Re: Objection to Planning Application 2026/90930 – 349 Whitehall Road, Wyke, BD12 9DP

I wish to formally object to planning application 2026/90930 relating to the demolition of the existing garage and erection of single storey side and two storey side and rear extensions with dormer windows at 349 Whitehall Road, Wyke, BD12 9DP, as detailed on the submitted plans.

Existing Ground Floor Plan  
Scale 1:100@A1

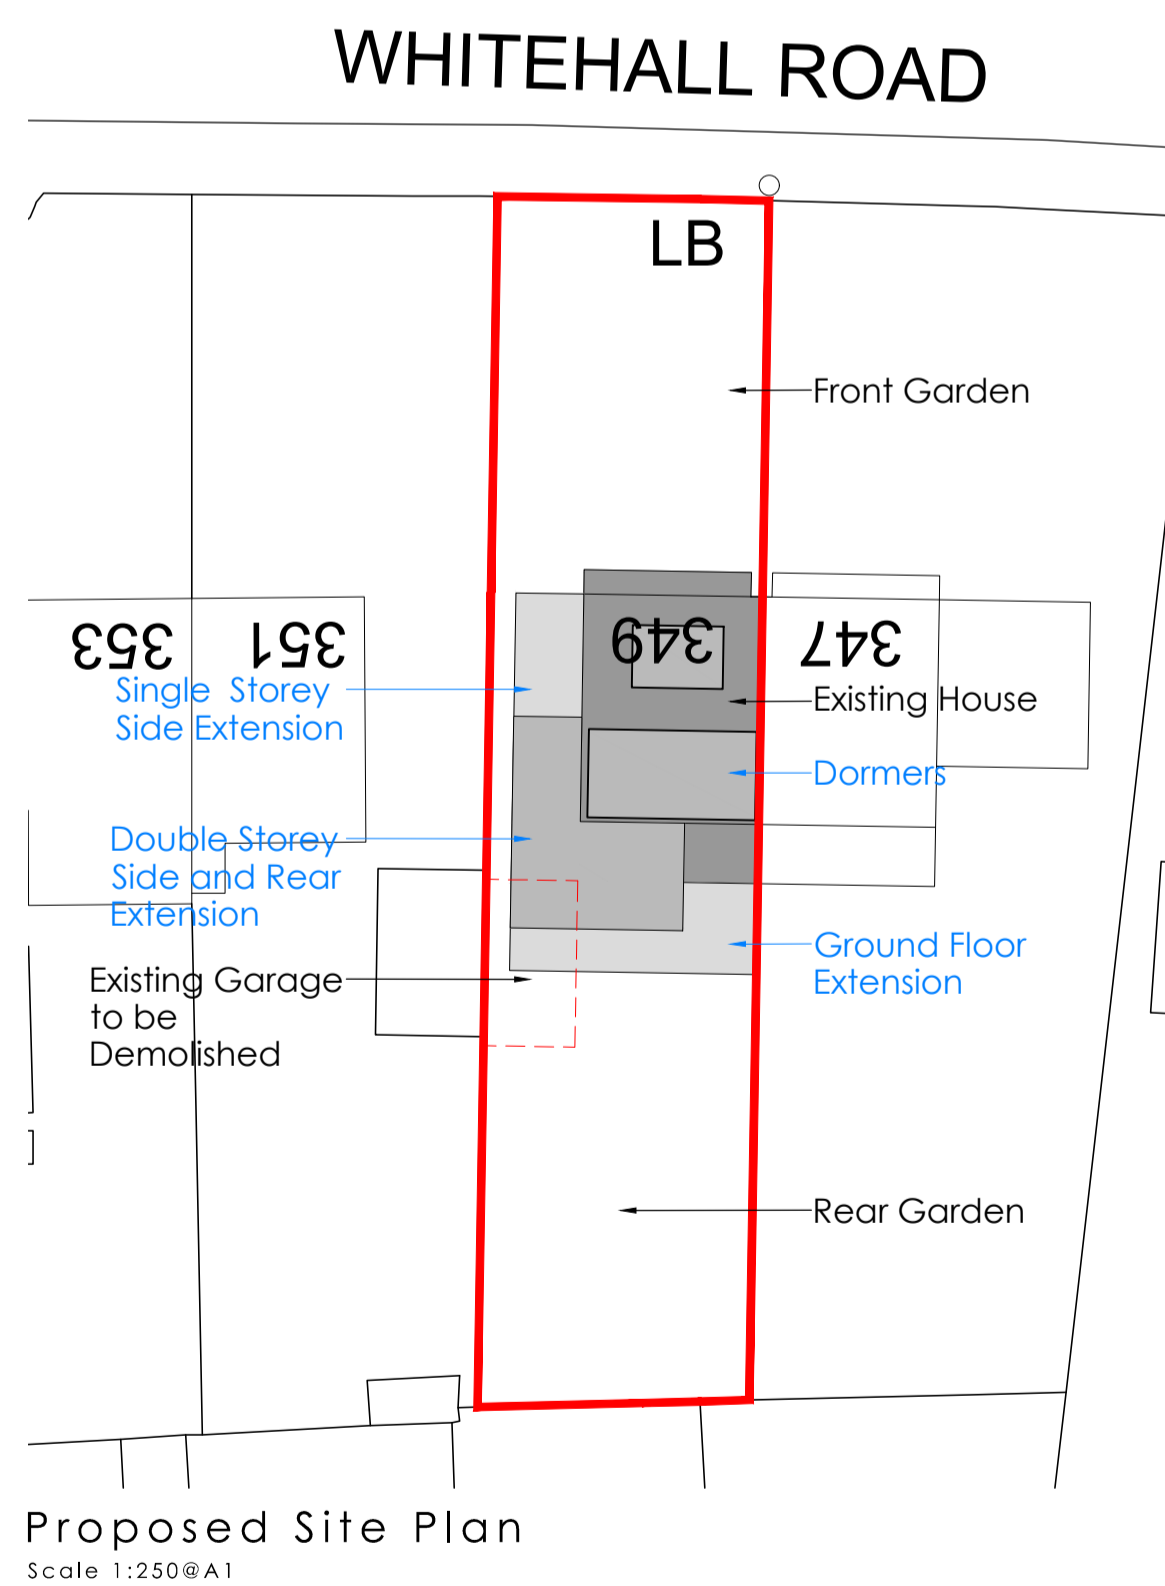
The proposed development represents an excessive and disproportionate enlargement of the existing dwelling. The submitted drawings show substantial extensions to the side and rear, together with significant loft alterations and dormer additions, resulting in a development that materially increases the scale, bulk and massing of the property.

The proposals appear to leave very limited spacing around the dwelling and result in an overly dominant form of development on what is a relatively modest plot. The combination of;

- a two-storey side extension,
- a substantial rear projection,
- a single-storey side extension,
- and a large rear dormer,

creates a cramped appearance that is out of keeping with the spacing and character of neighbouring properties along Whitehall Road.

Client	N/A
Project	N/A
Address	349 Whitehall Road, Wyke, Bradford BD12 9DP
Title	Existing and Proposed Elevations

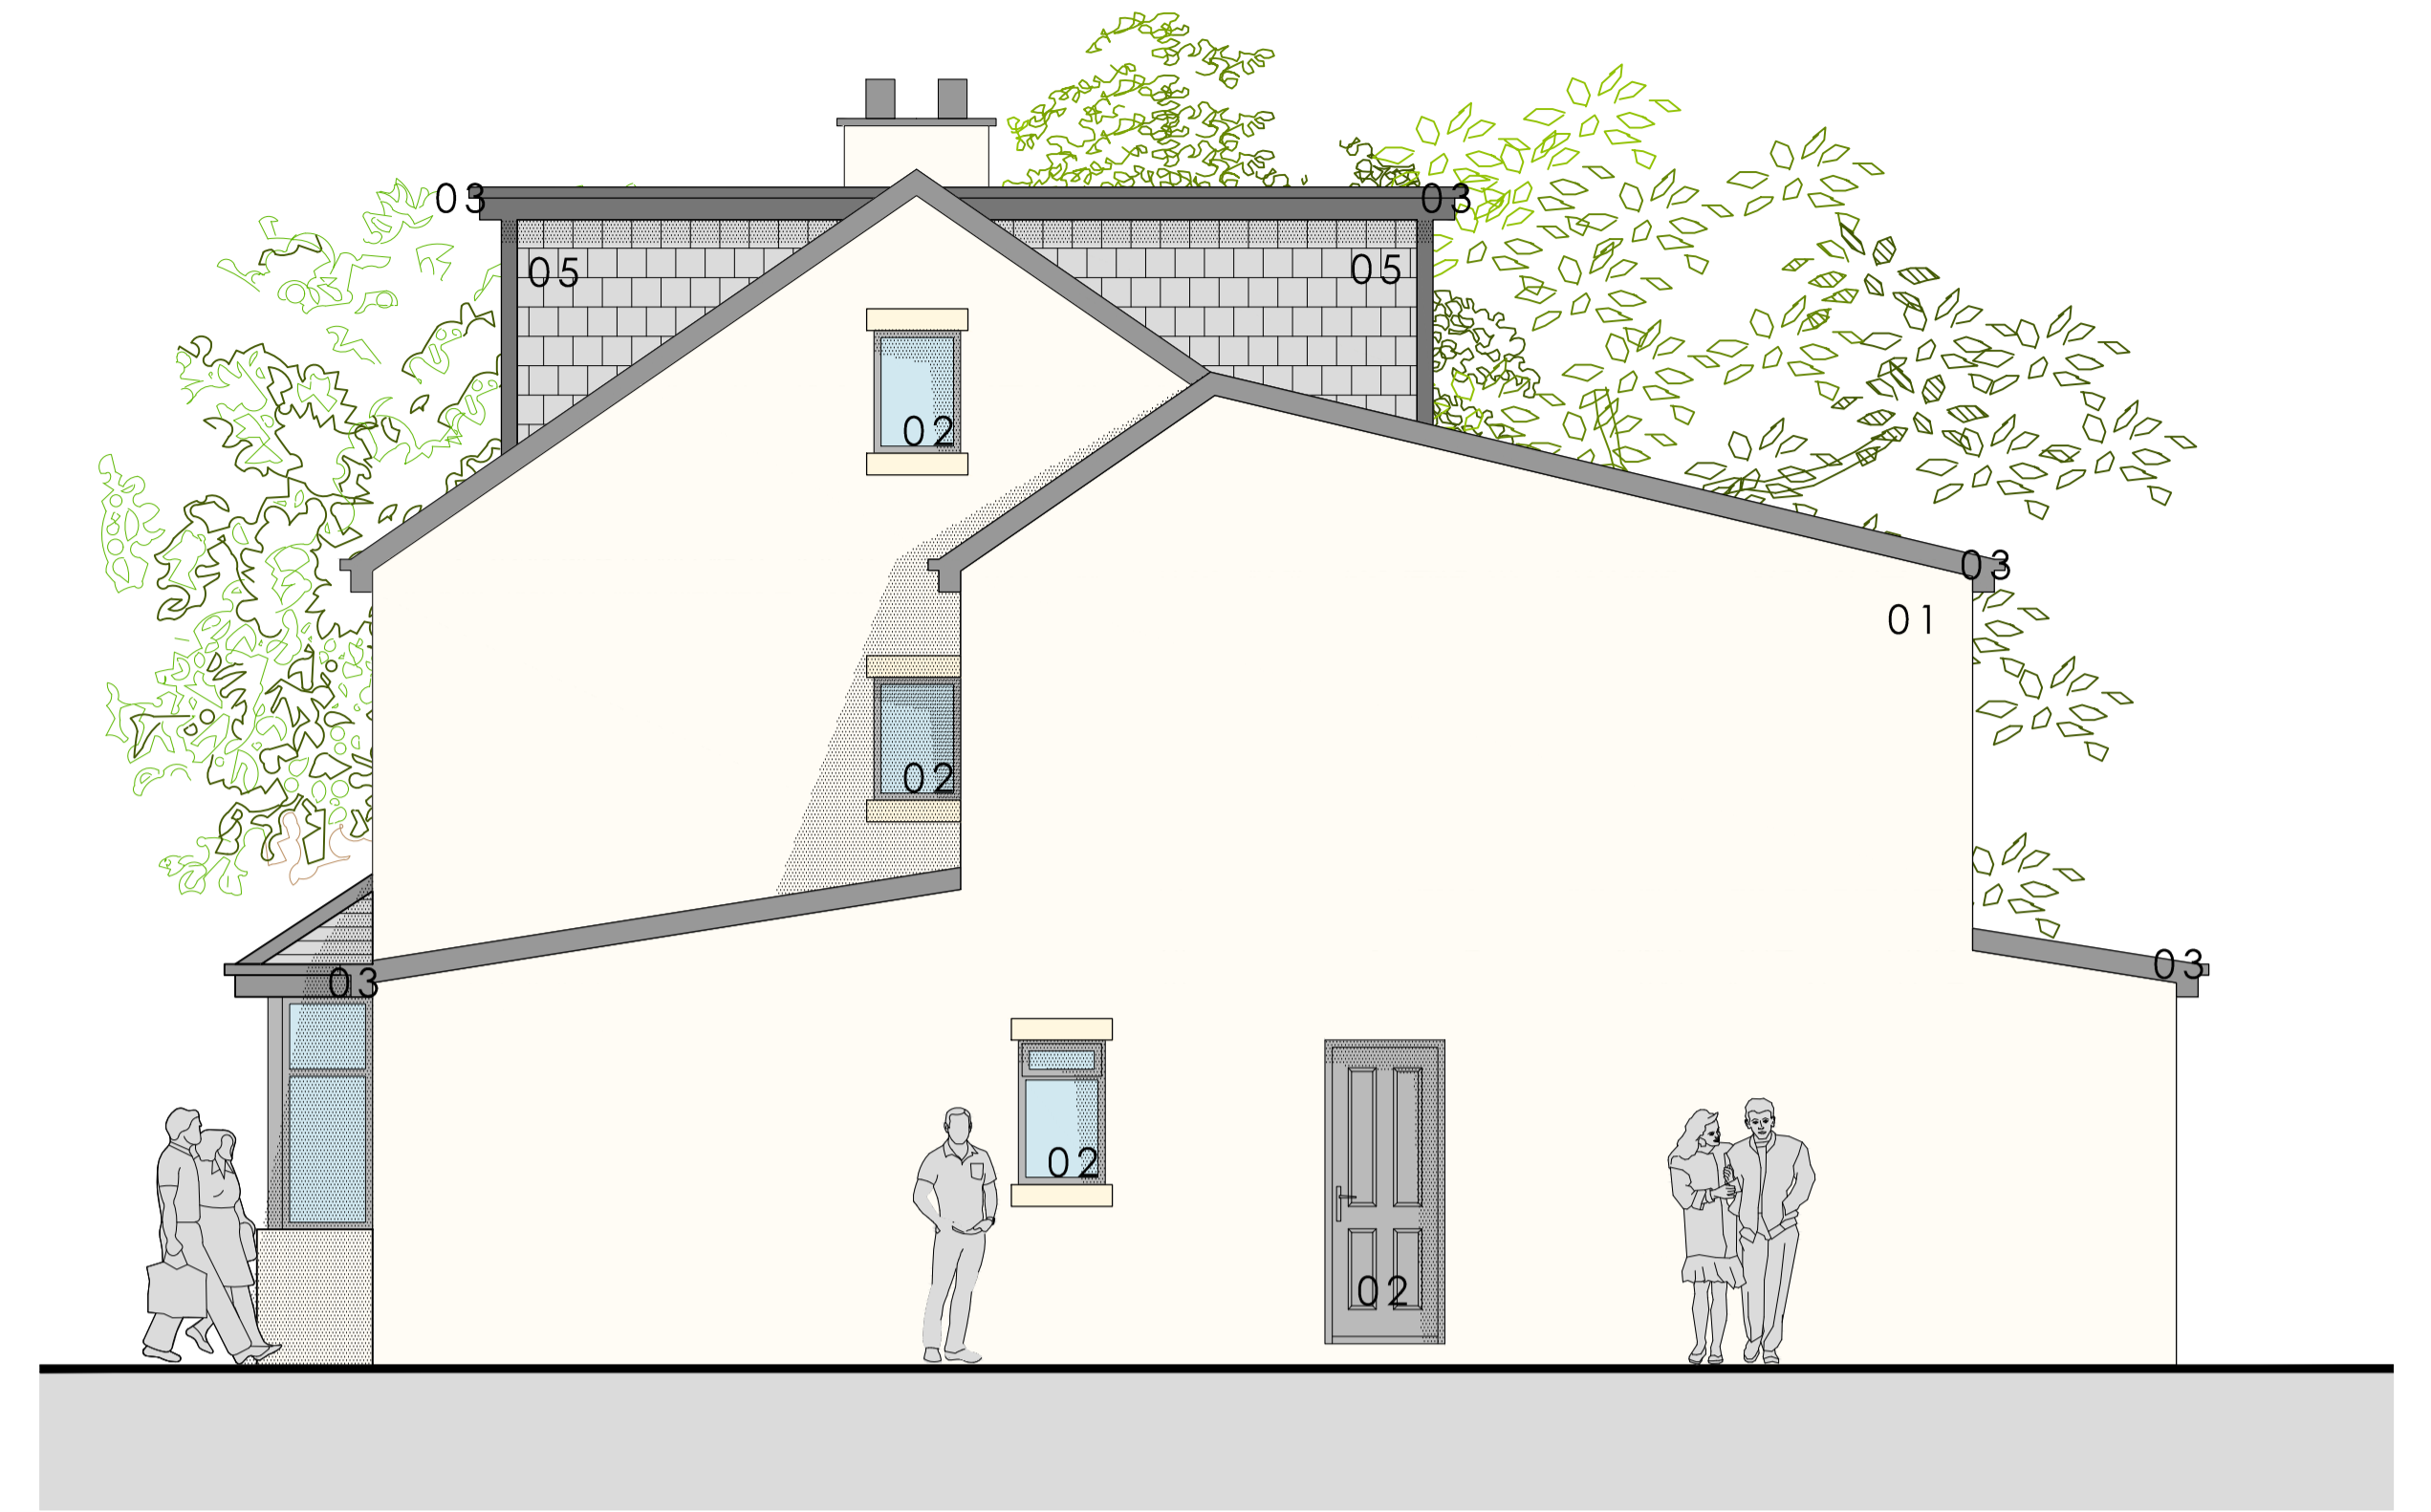
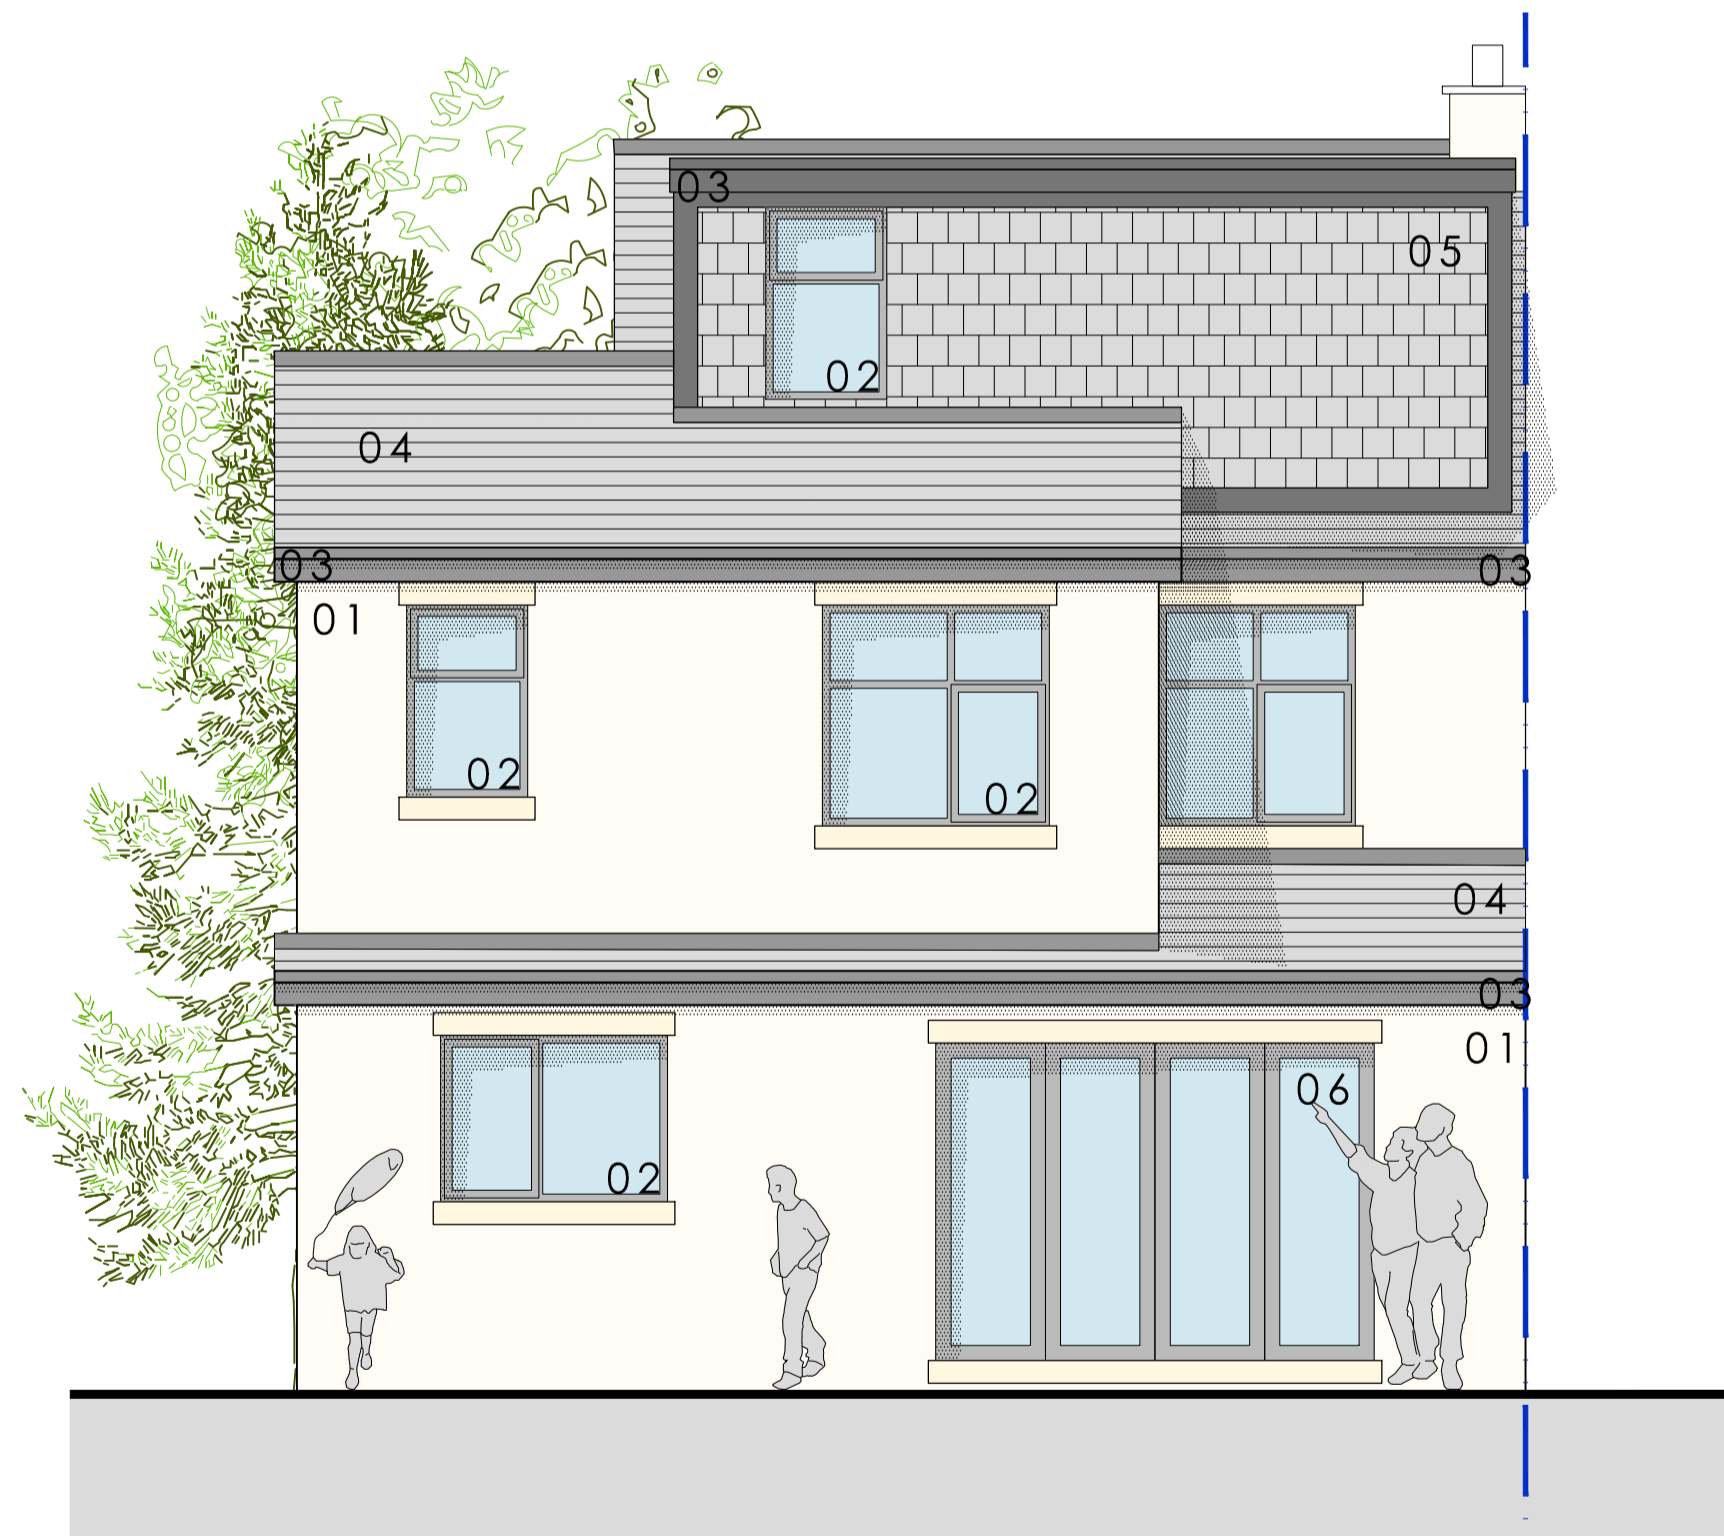
The proposed two-storey side and rear extensions substantially increase the height and depth of the built form close to neighbouring boundaries. The enlarged side elevation and rear projection shown on the submitted drawings raise serious concerns regarding overshadowing and reduction in daylight to adjoining habitable rooms, garden and outdoor amenity spaces.

The rear dormer appears excessively large and fails to appear subordinate to the existing roof form. Combined with the extensive side and rear additions, the proposal risks creating a property that is materially out of scale with neighbouring homes.
